DRB Application No.: 06DRB-00748 (P&F)

Project Name: NETHERWOOD PARK ADDITION

**June 7, 2006
DRB Comments**

RE: Lots 47 & 48, Block 19, Netherwood Park Addition/p & f

## PLAT OF LOT 48-A NETHERWOOD PARK ADDITION BEING A REPLAT OF LOTS 47 AND 48, BLOCK 19 SEC. 10, T.10N., R.3E., N.M.P.M. ALBUQUERQUE, NEW MEXICO

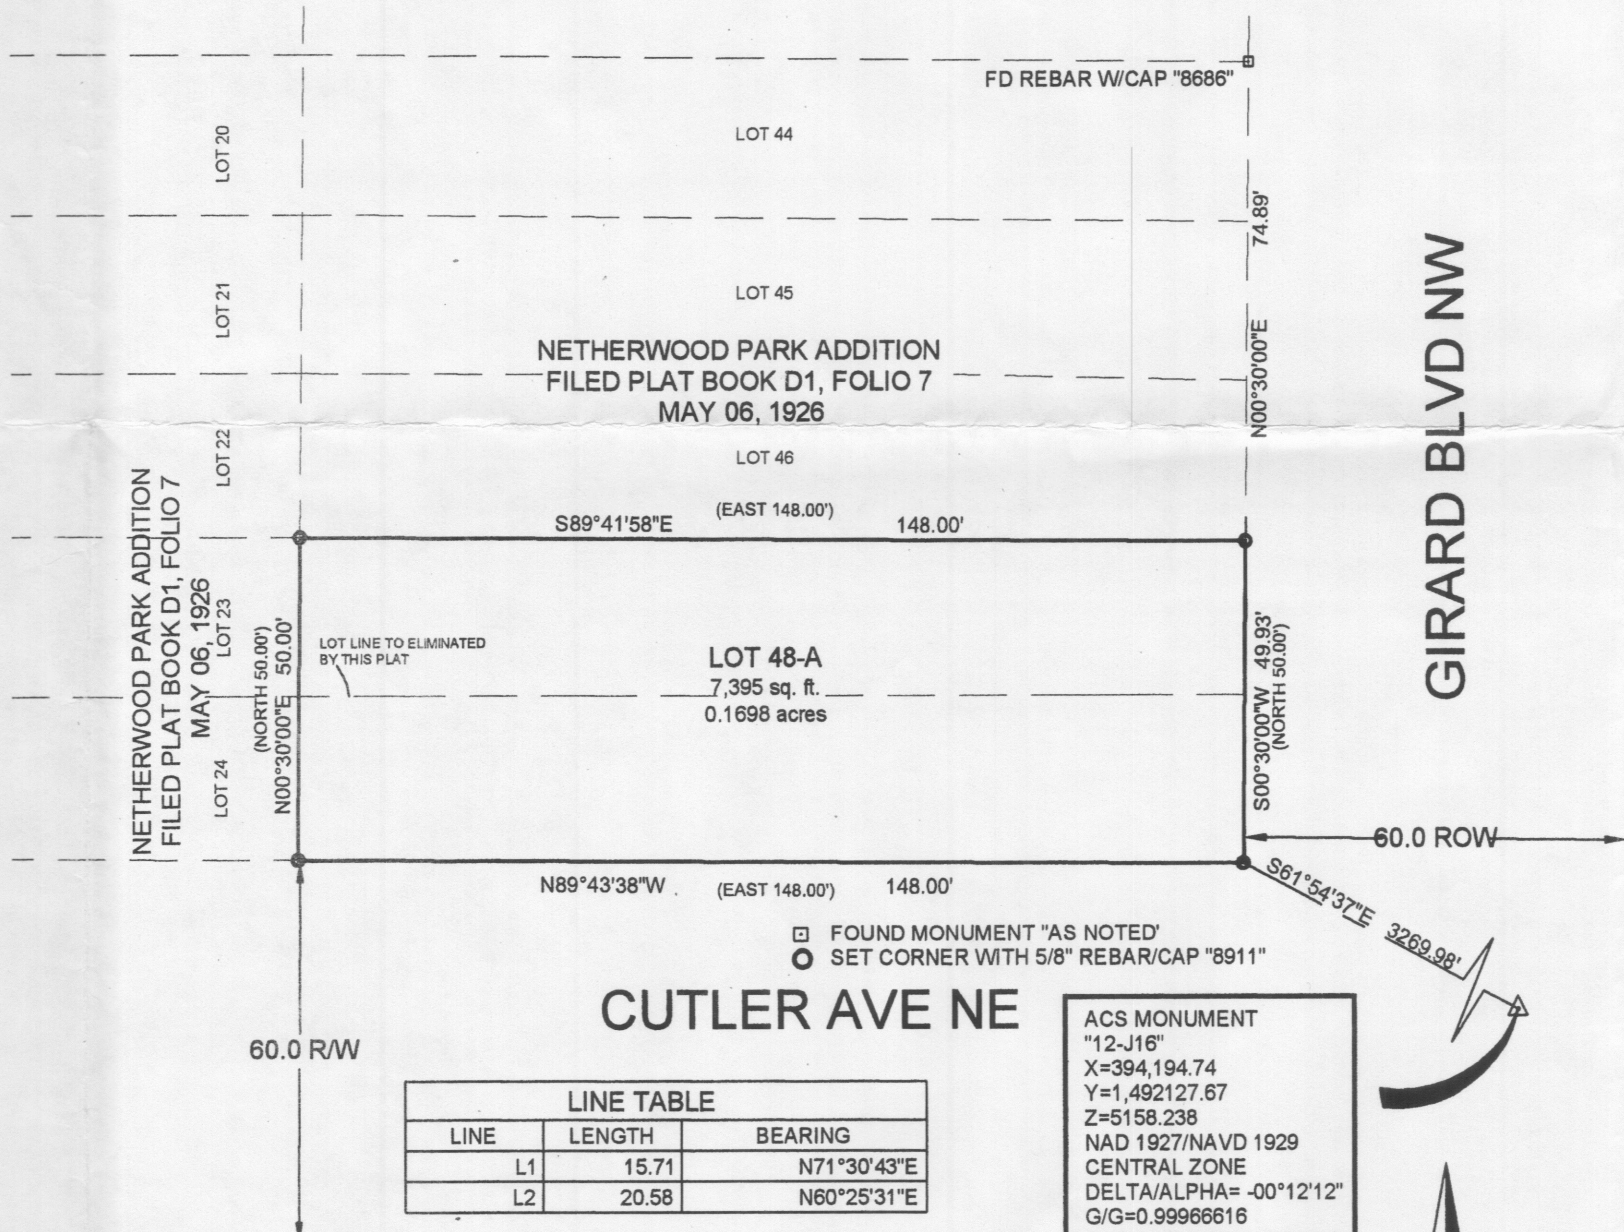
TRANSPORTATION: Cross section ^{and radius} on Girard

PLANNING (Last to sign): Change Plat - Zoning should be R-3

Your plat shows that the zoning is RD/9DU per acre and the application shows R-1. The Actual zoning is R-3. Which is the correct zoning?
